Date: 07 June 2023  
Our ref: 431220  
Your ref: EN010132

**NSIP Reference: EN010132**

## **Natural England's comments in respect of West Burton Solar Project**

Drawing file: EN010132 / EN010132-001122-WB6.4.8.18.3_A Figure 8.18.3 -Landscape and Ecology Mitigation and Enhancement Plan - West Burton 3.pdf

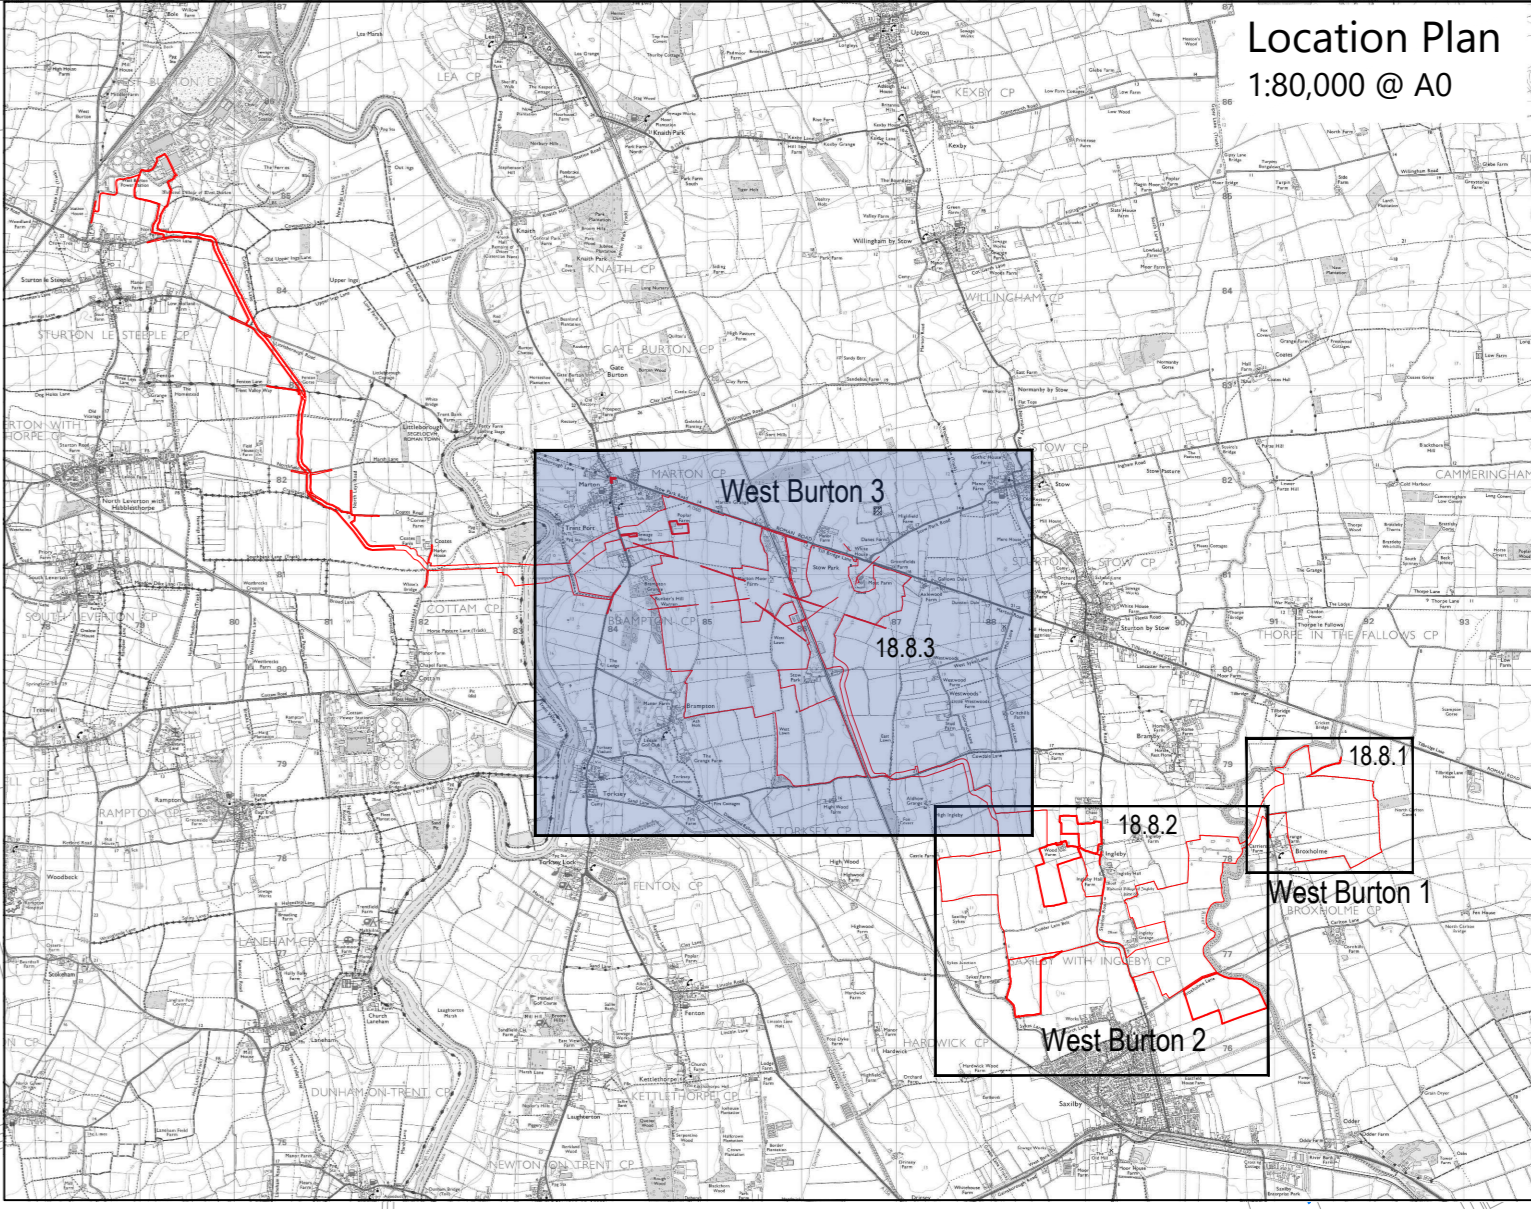
- Overall, Natural England welcome the biodiversity enhancement proposals, illustrated in the Landscape and Ecology Mitigation and Enhancement Plans (ES figures 8.18.1 to 8.18.3).

Based on the information provided within the Environmental Statement (ES) (Chapter 19: Soils and Agriculture and Appendix 19.1 Agricultural Land Quality, Soil Resources & Farming Circumstances), it appears that the proposed development will result in the temporary development of 886.4ha (19.3.5), of which 199.5ha is BMV agricultural land (Grades 1, 2 and 3a land in the Agricultural Land Classification (ALC) system), as determined from detailed ALC surveys. It is acknowledged that some of the order limits will remain in arable use (i.e. N24, N26, N28, N29, N30 & N31 as illustrated in figure 8.18.1).
